From: Amanda Scholes on behalf of Planning.Responses
Sent: 02 January 2018 08:46
To: Planning Scanning
Subject: FW: FG/183/17/PL - Land adj to The Barn, Hangleton Lane, Ferring

WSCC highways consultation

Subject: RE: FG/183/17/PL - Land adj to The Barn, Hangleton Lane, Ferring

DRAWING TITLE
Proposed site plan,
Block plan and Location Plan

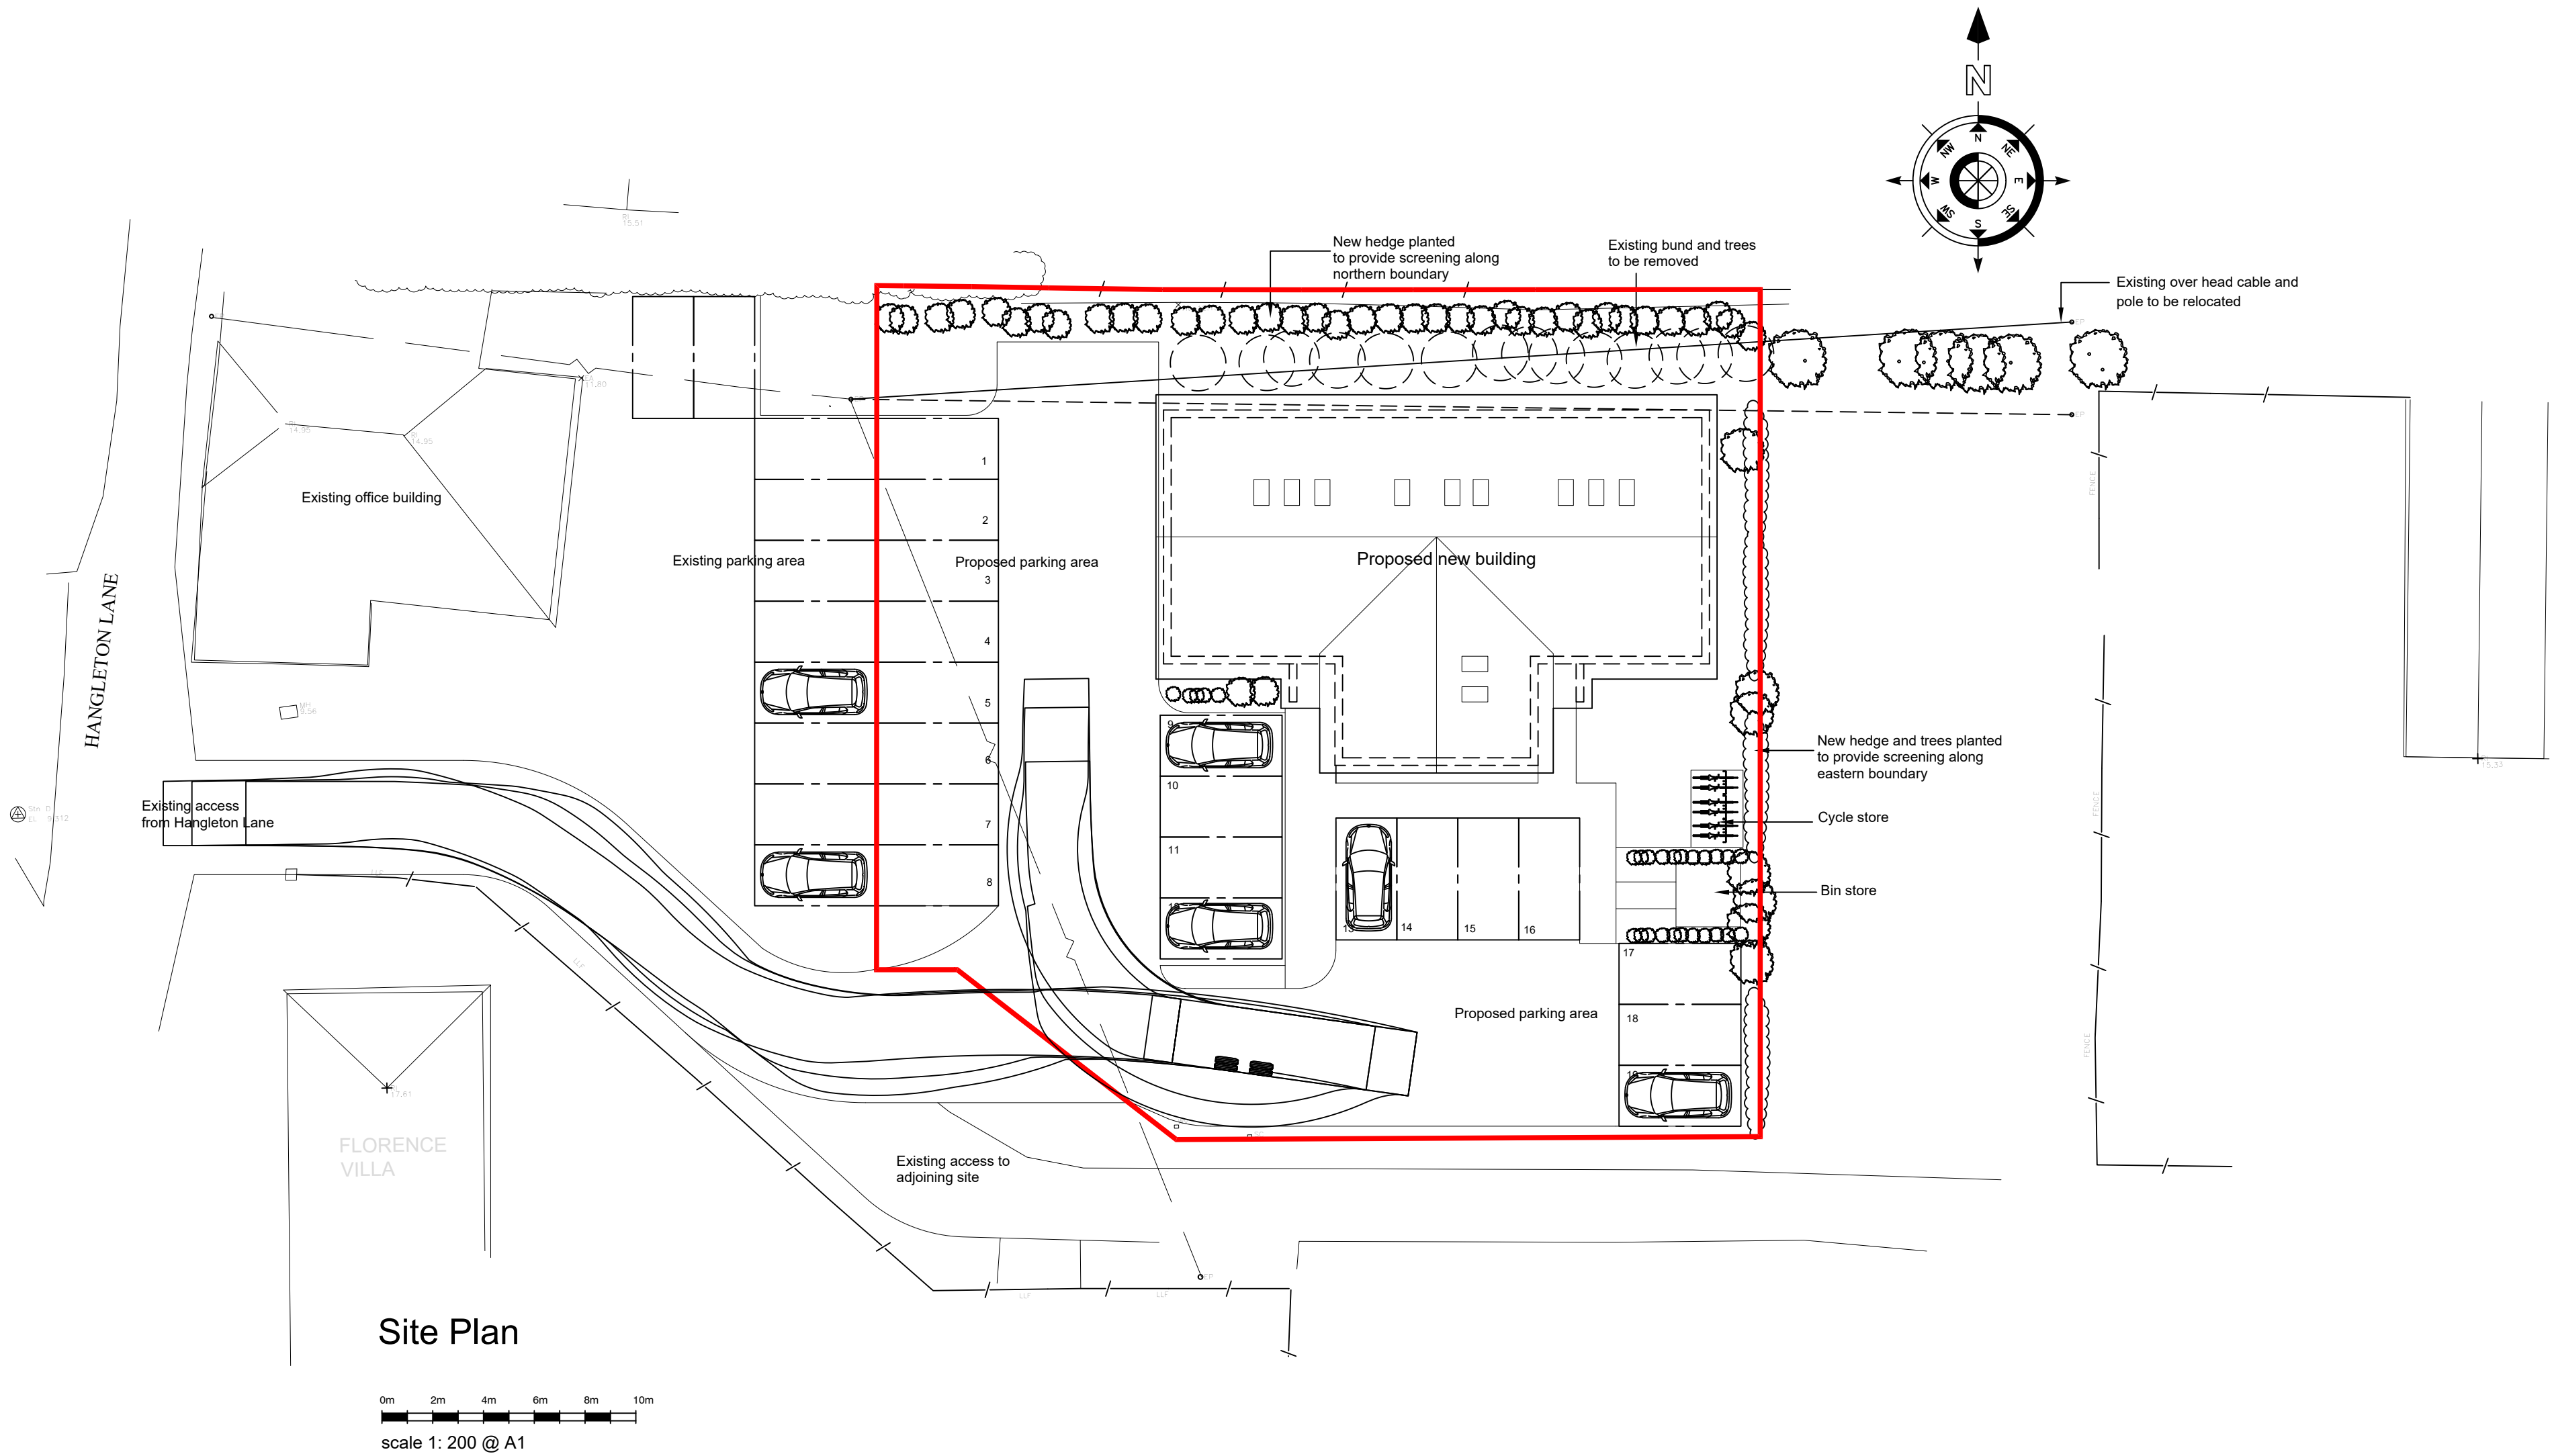
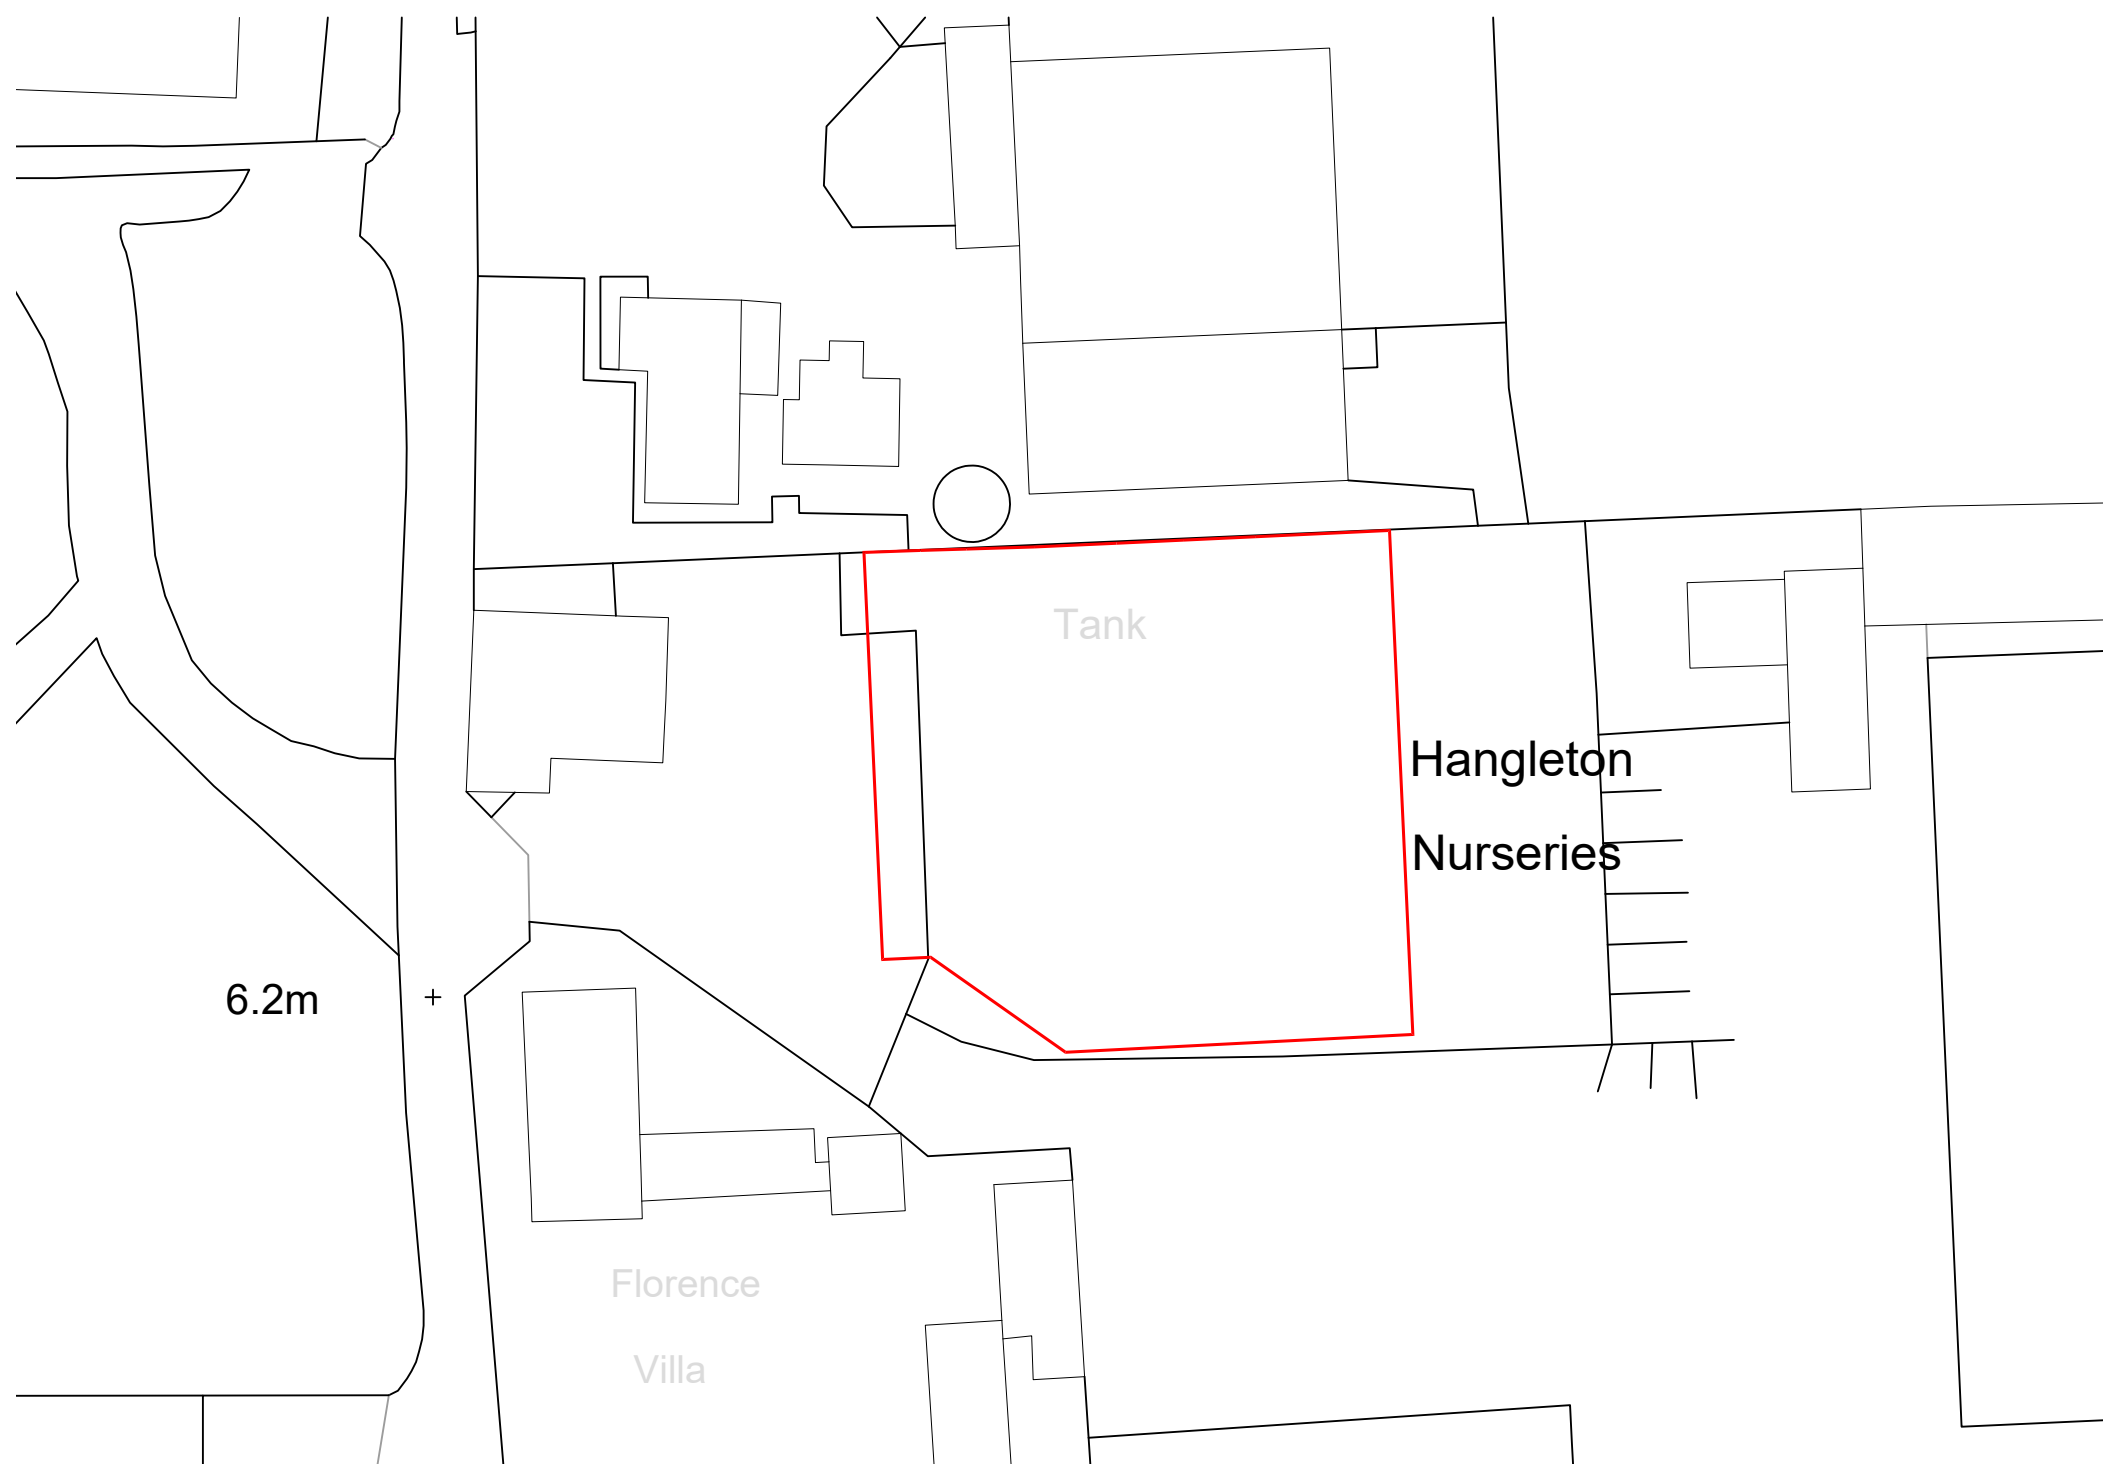
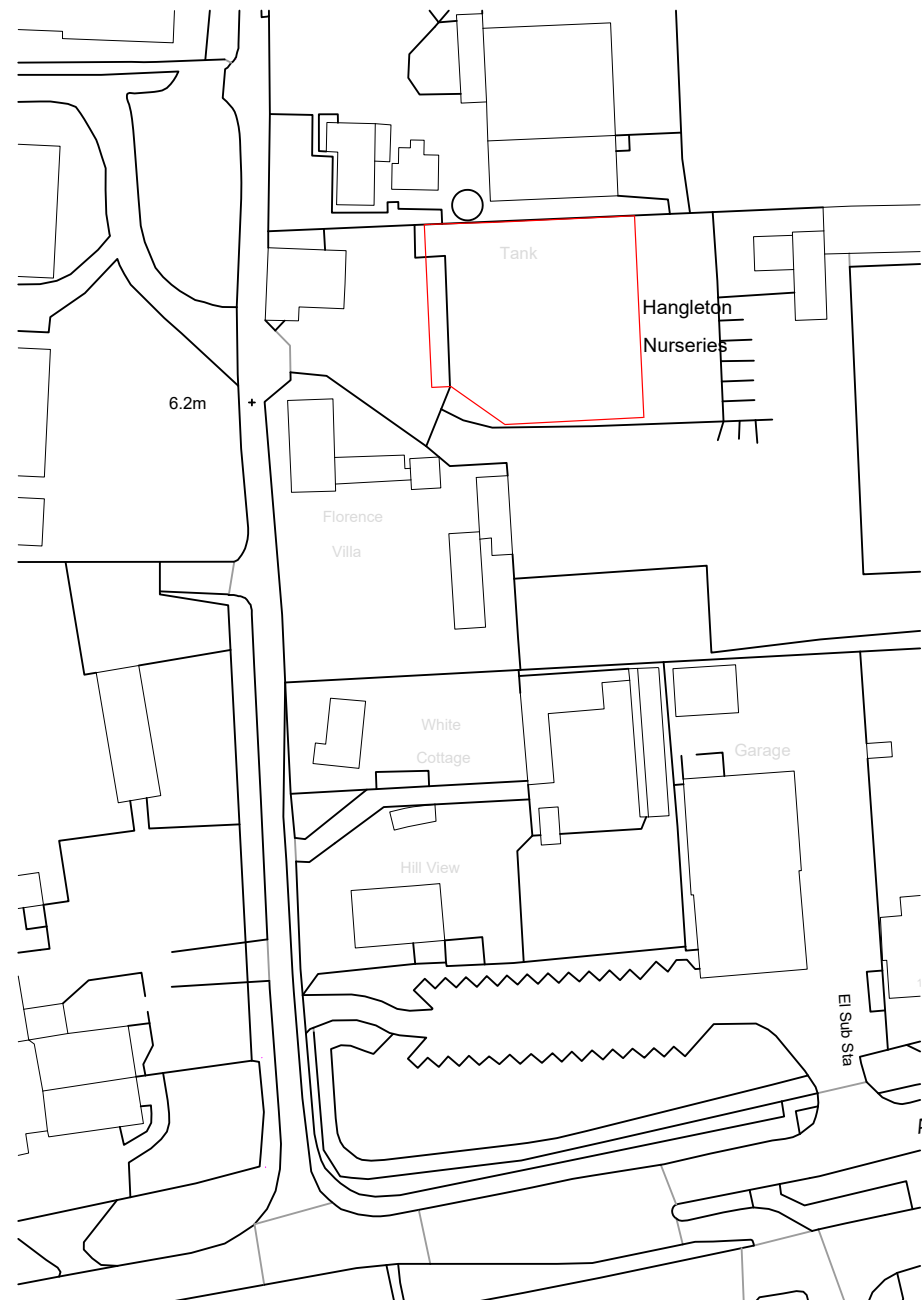
In terms of the vehicular access, I note that this is existing and has been in use in association with various uses, although it's not apparent how intensively used this might have been. Even so, I recognise that the proposal would not give rise to a significant number of extra traffic movements. Visibility from the access also appears restricted. The nature of the lane however is such that this would constrain speeds and in practice achievable sightlines are most likely comply with Manual for Streets requirements.

With respects to pedestrian trips, the potential number is clearly very low. It would be unreasonable and unnecessary to seek improvements in light of this increase, notwithstanding the fact that improvements could not be delivered without 3rd party land being acquired.

I've been passed your comments dated 13/12/17 on the application. I note you have raised questions with regard to the vehicular access and pedestrian access. I have looked at this further and I have the following comments:

The existing access is shown in the attached Google extract. It is around 7m wide although may have been partially overgrown. The site was previously used for vehicle storage and it is likely that it would have been used by larger vehicles delivering cars. The proposed use is generally going to be car trips with deliveries and refuse collection, so once a week at most. Therefore, the existing access would seem adequate.

As you have highlighted, there is no footway along the majority of Hangleton Lane and little prospect of delivering one due to land ownership issues! There is of course, a short section of footway on the east side of Hangleton Lane close to the A259 junction. In addition, on the A259, there is a wide footway/cycleway which leads to a TOUCAN crossing to the east. There is then a cycleway/footway running along the A259 to the east and west. Therefore, there are good local facilities within a short distance of the site. You specifically asked for the numbers, so we have looked at the TRICS Database. This suggests that as a maximum, there would be one additional pedestrian trip in each peak with up to 15 in a day, although I believe the actual numbers will be less in this location. I would therefore, suggest that bearing in mind the slow nature of vehicle speeds and the relatively low flows, then pedestrian can walk in the lane for the short section up to the site.

On this basis, no highway objection would be raised to this proposal.
